CAGNE Surface Access Transport Update – Response to D5 Submissions & ISH8

Sterling Transport Consultancy Limited

15 July 2024

Title
**Surface Access Highways Plans
Engineering Section Drawings
APFP Regulations 6(2)
Sheet 2 - Longbridge Sections**

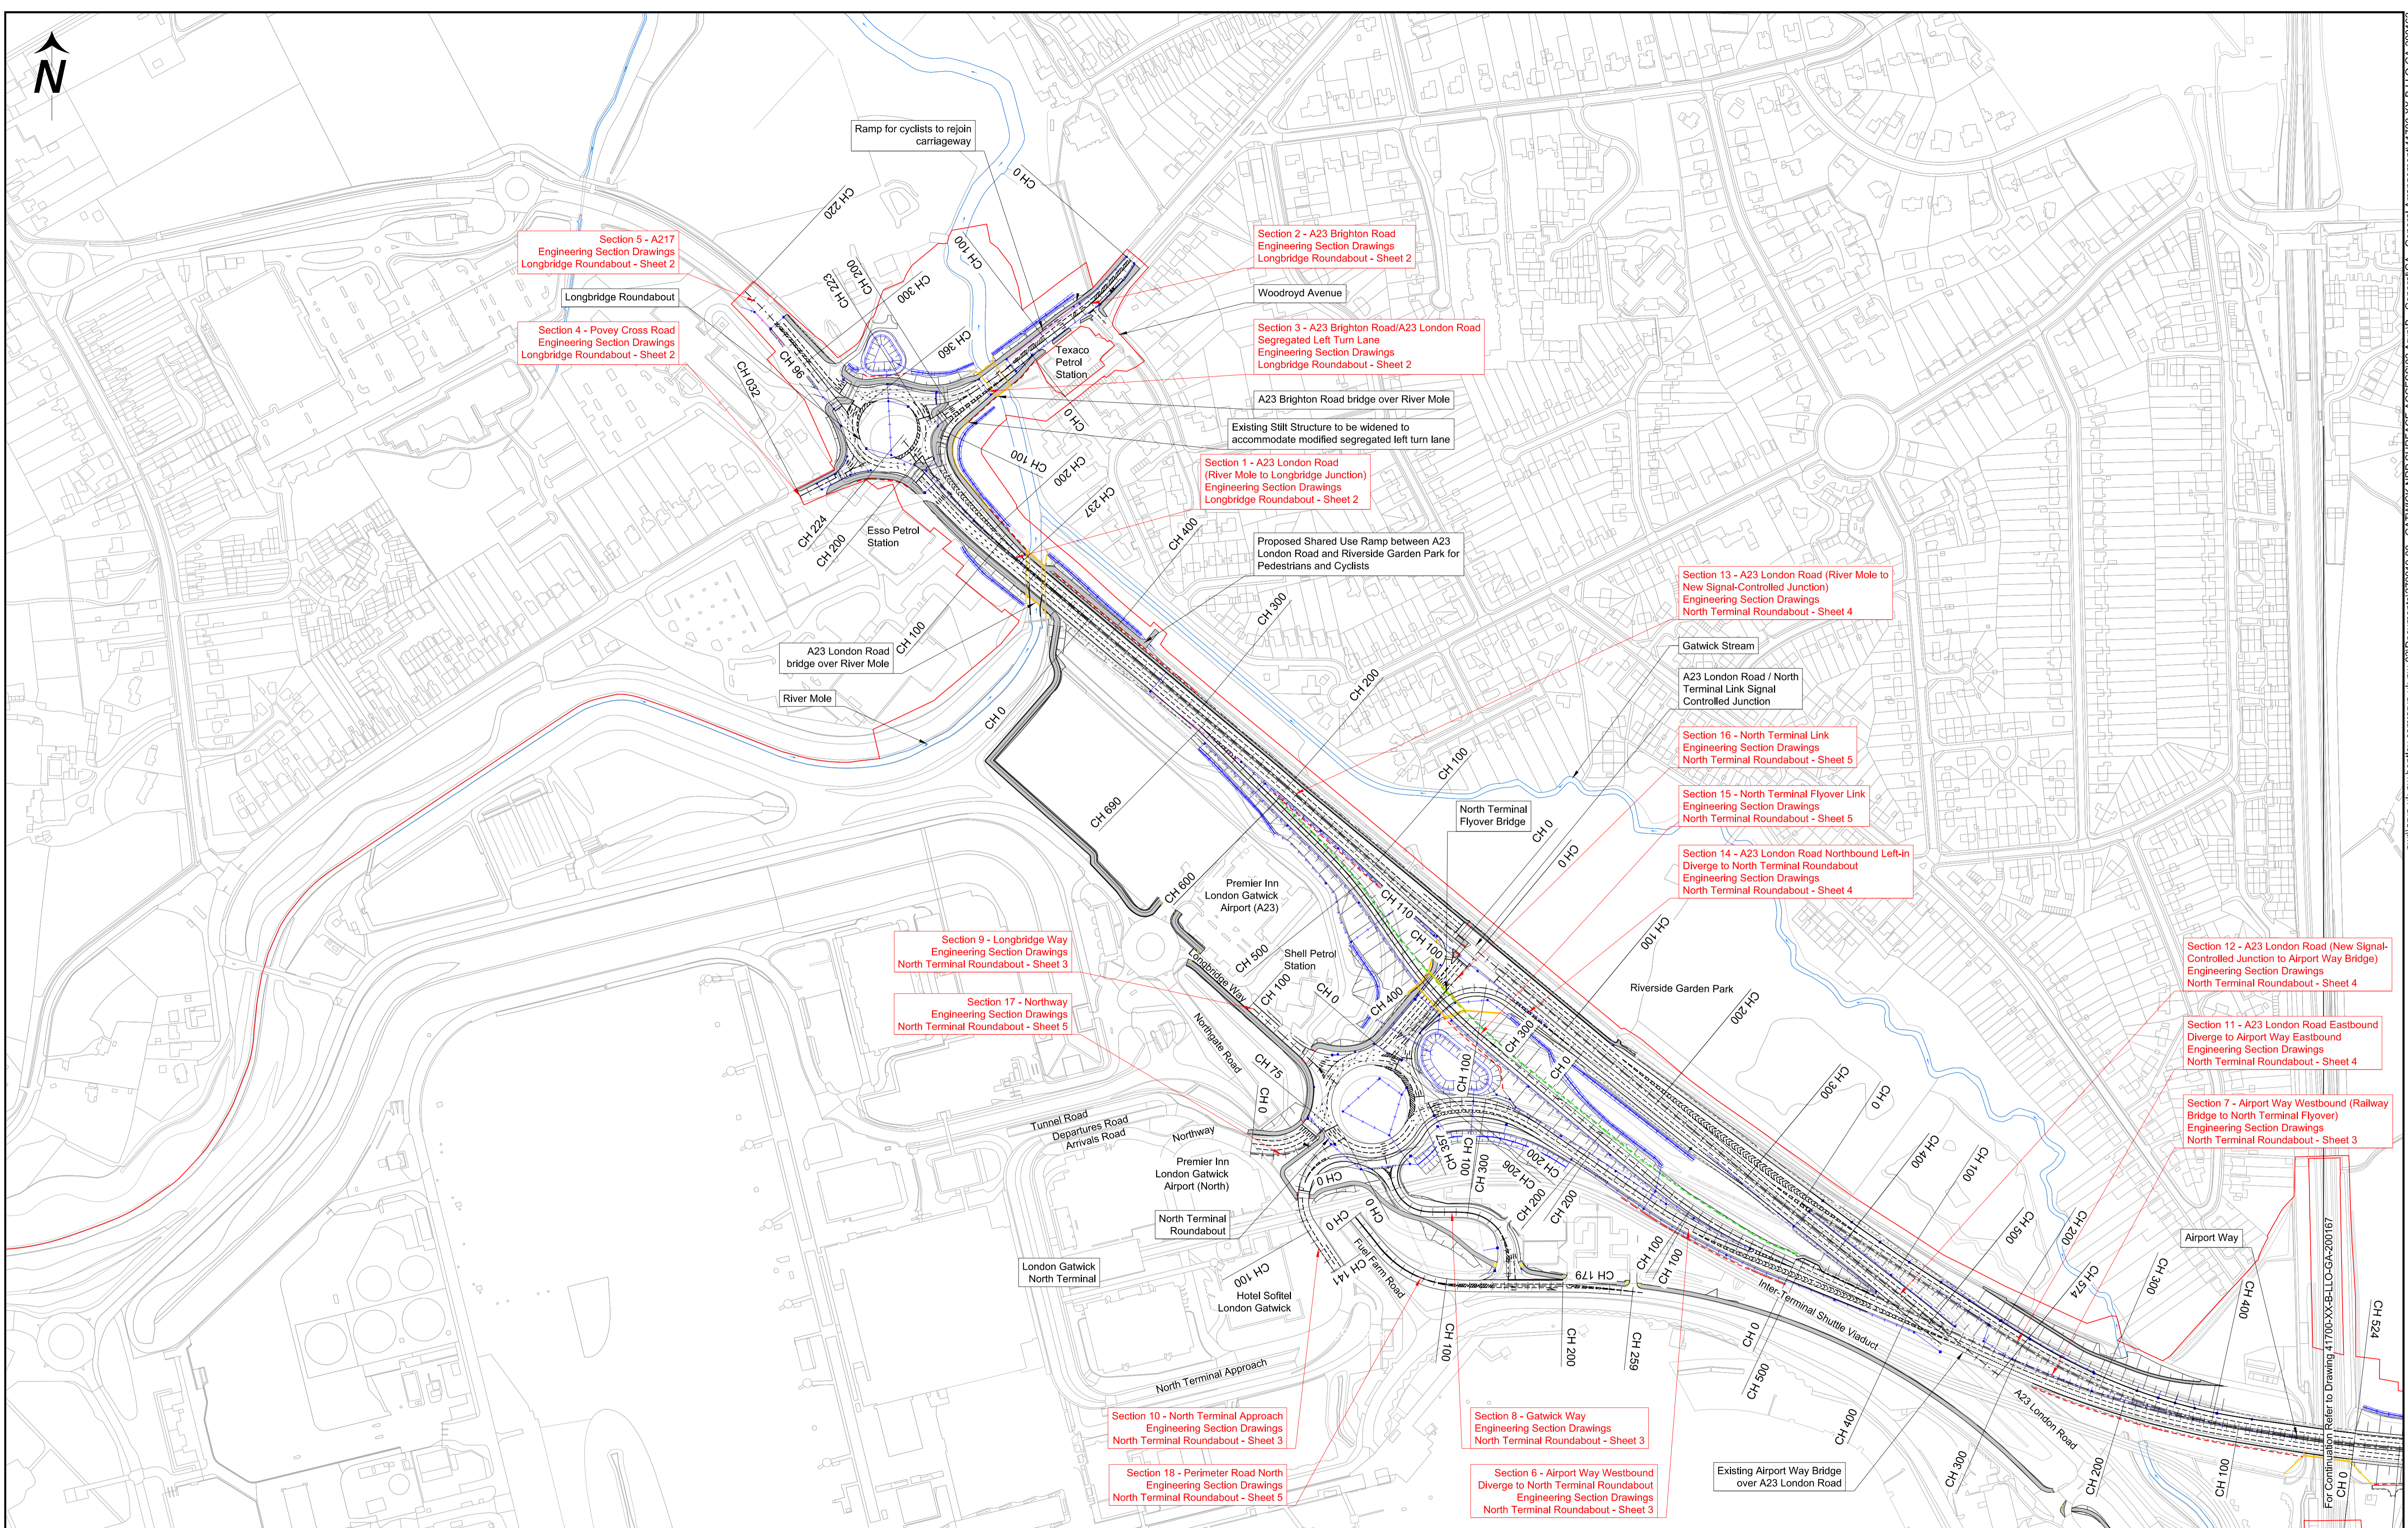
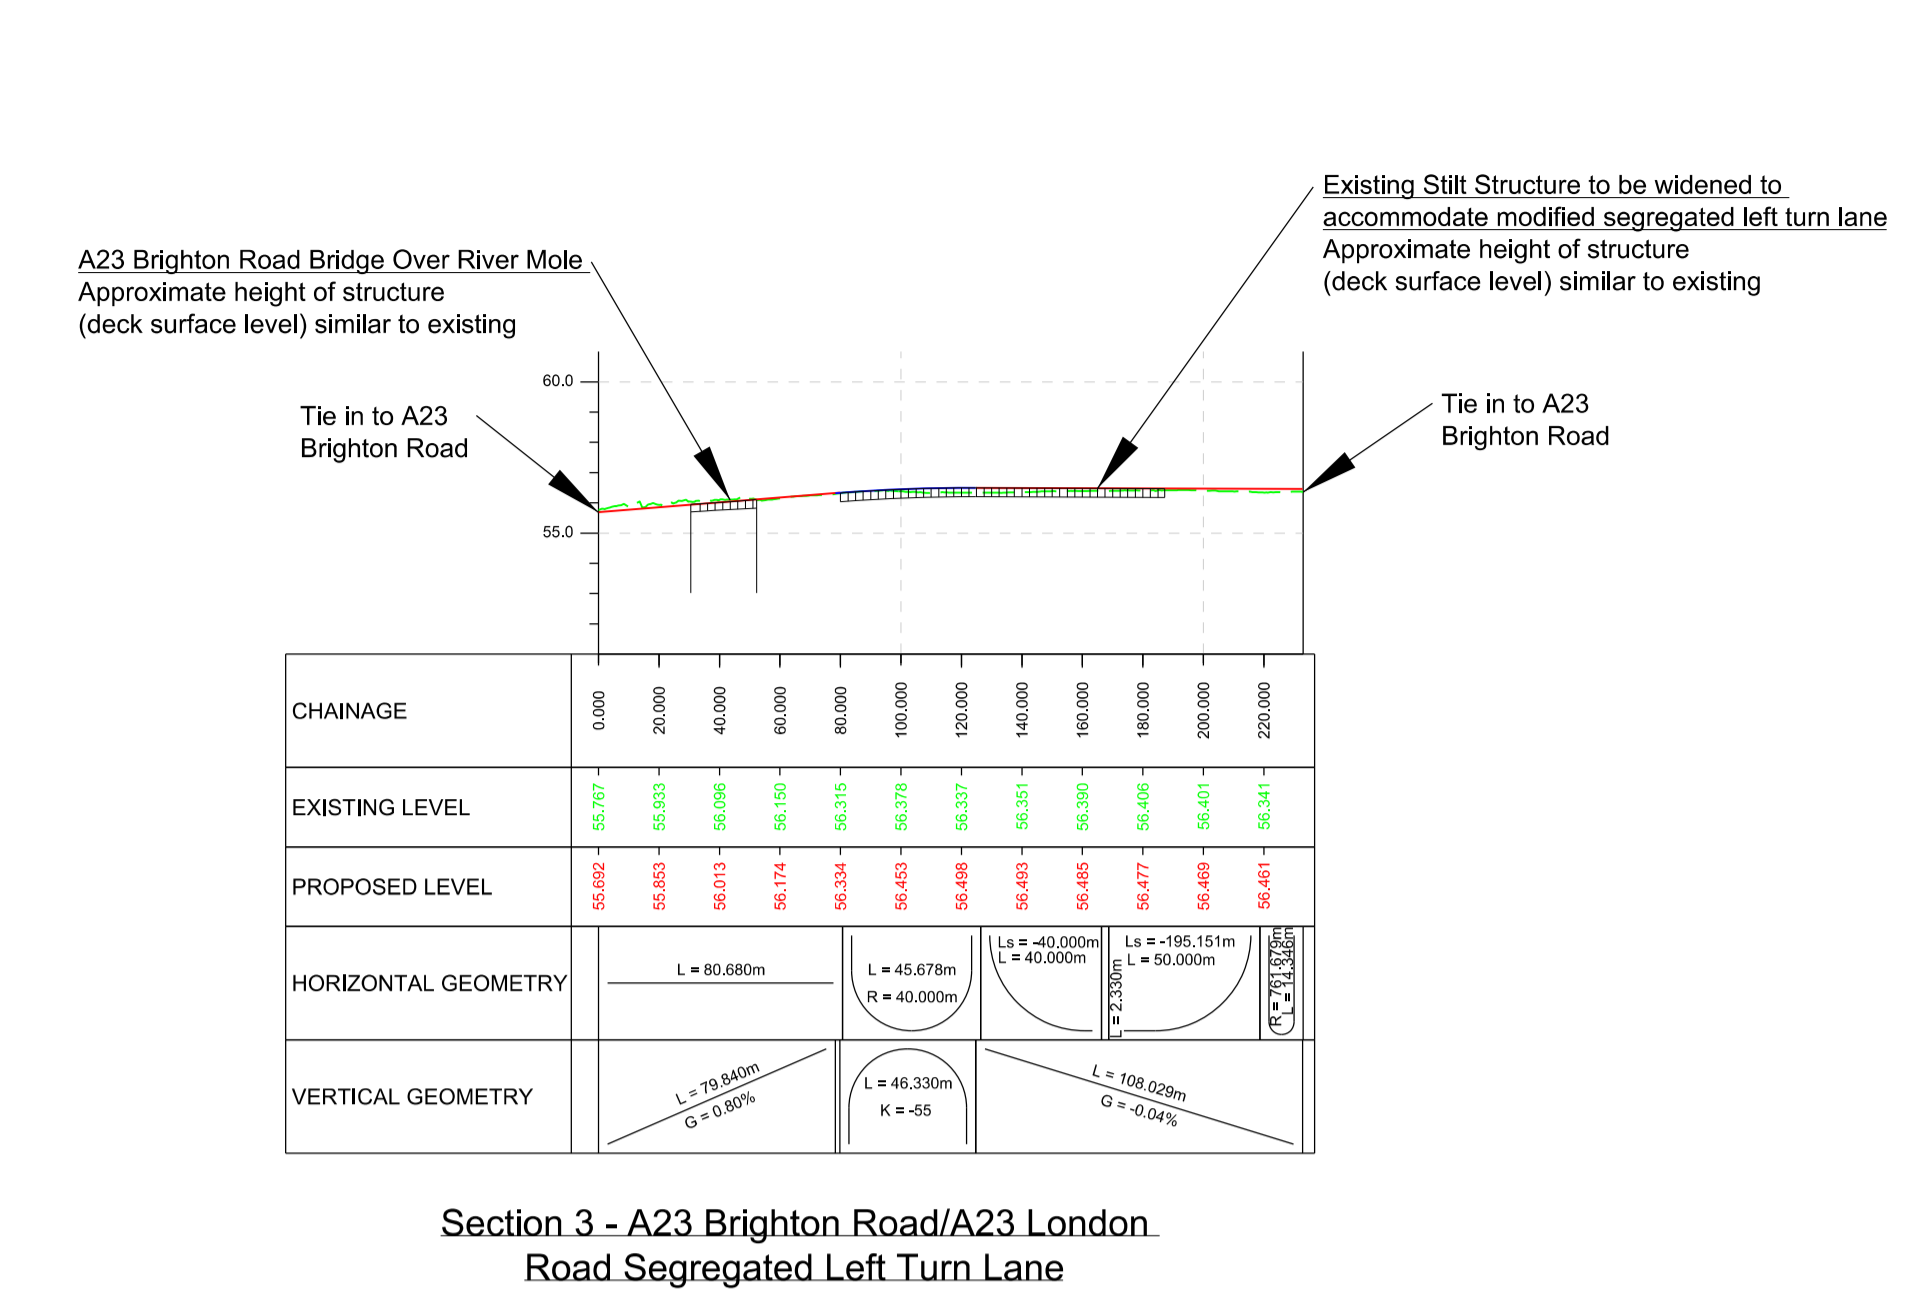
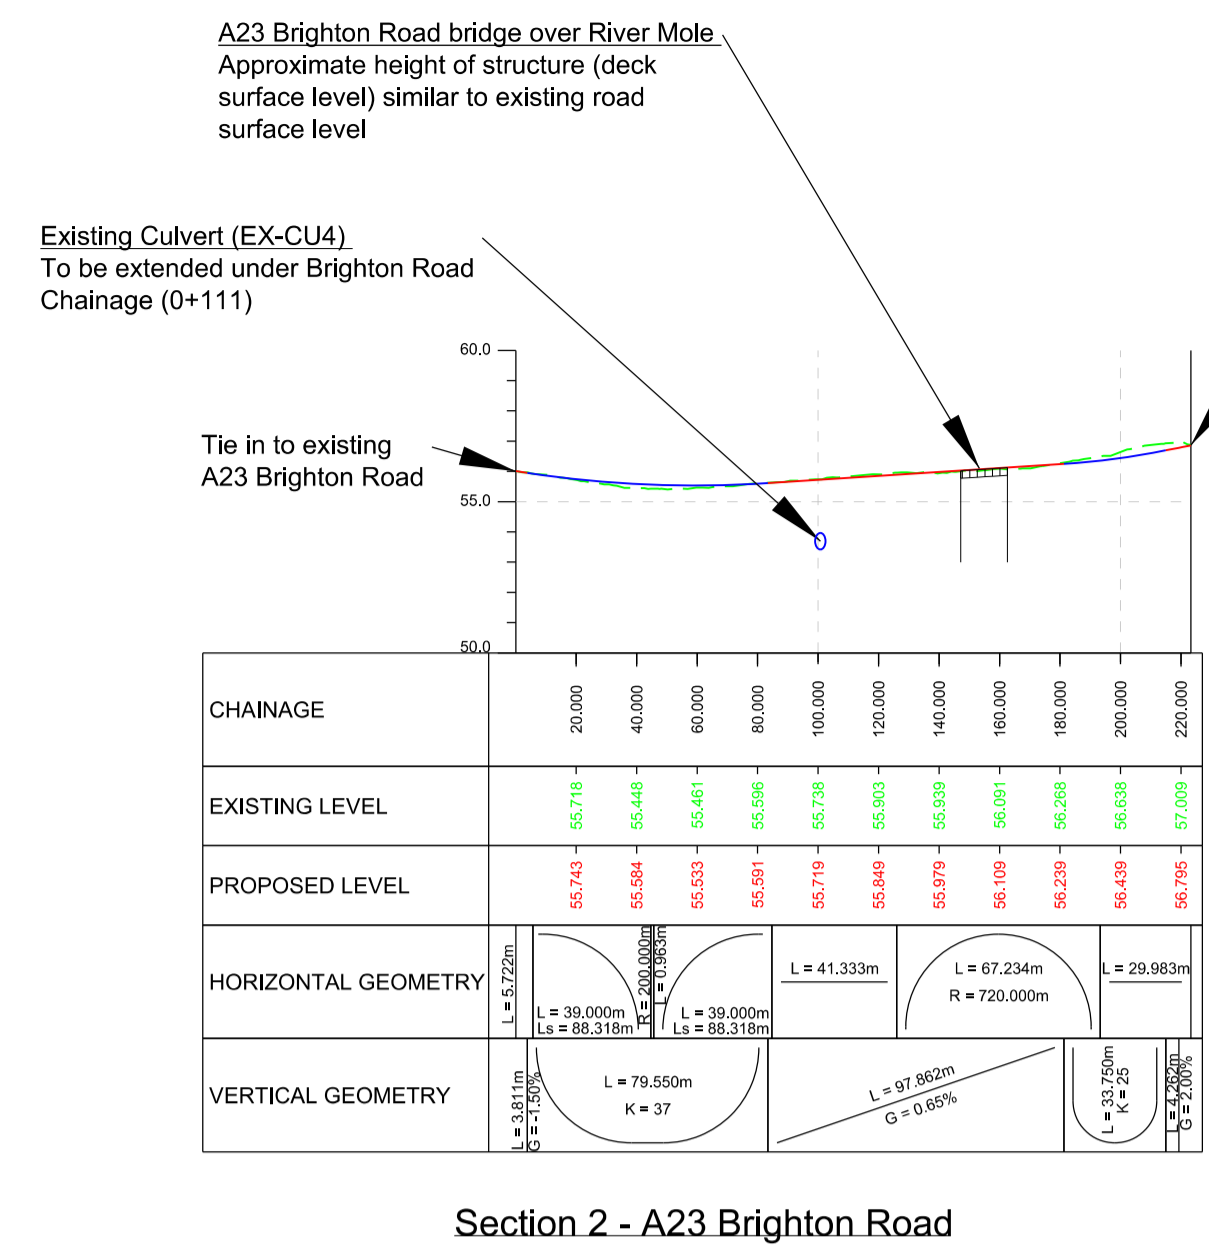
The applicant in the scope of works set out in the ES highlights a potential North Terminal link between the A23 London Road / North Terminal Link signal-controlled junction crossing and the proposed signalised crossing on Longbridge Way. Given the need acknowledged by the applicant to improve local connectivity for sustainable travel modes to ensure these are effective CAGNE considers that this work should be fully committed to by the applicant and not left as "optional extra" given the key link this creates in access to the north terminal from the A23 road.
